An Coimisiún Pleanála
64 Marlborough Street,
Dublin 1, D01 V902.

19th June 2026

**Objection to Strategic Infrastructure Development Application:
Tirawley Wind Farm (Your Ref: PAX16.324258/ Case 324258)**

Figure 4.1: Wind Farm Site overlain on Map 8 of the Mayo RES

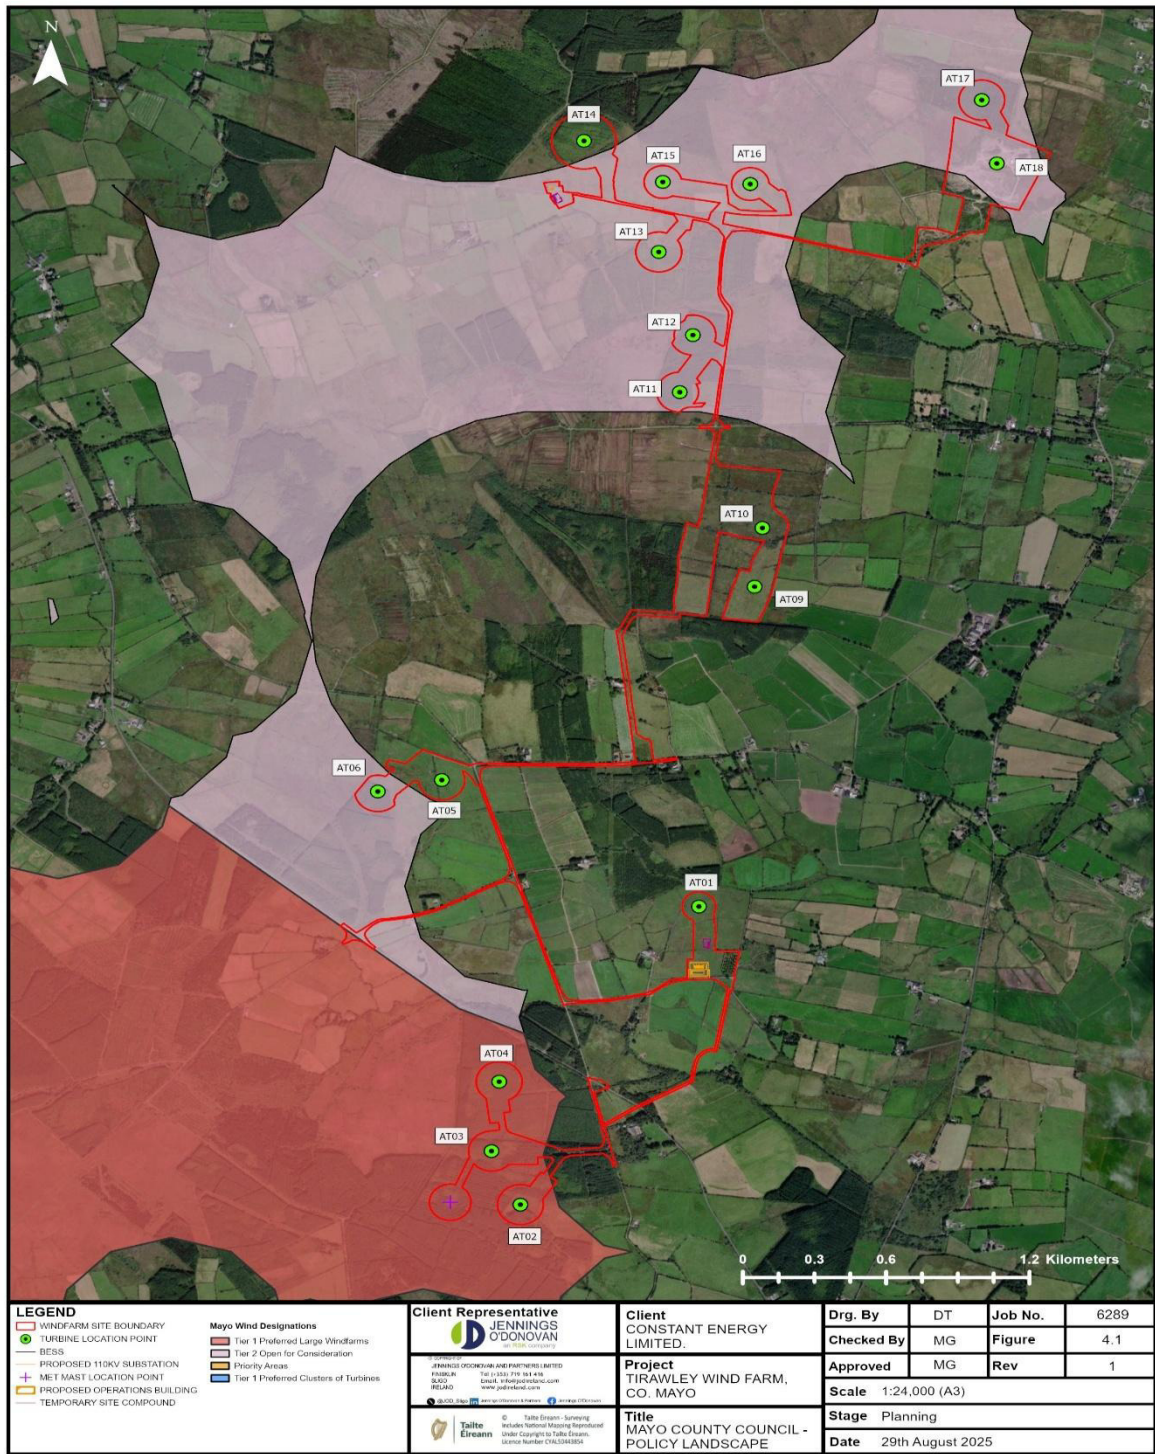
Each of the iterations of this Windfarm design have placed the overwhelming majority of the turbines in locations not deemed suitable for development. Indeed, the final design presented in the current application before ACP contains a *greater* proportion of turbines in non-designated areas than previous versions (pg.26, Ch. 13). The application fails to provide sufficient detailed explanation as to these turbines should be permitted outside the areas identified by the MCC as suitable for renewable energy developments.

In 2023, ABP representatives emphasised to the applicant that a strong, location-specific justification is required for turbines outside designated zones and that the justification for the layout must be clear (pp. 5-7, Meeting ABP 315864-23; pp. 5-8, ABP-323906-25 - 1st Meeting Record); this was a recommendation that, again, had to be stressed to the applicant three years later in January 2026 (pg. 4, ABP-323906-25 - 1st Meeting Record).
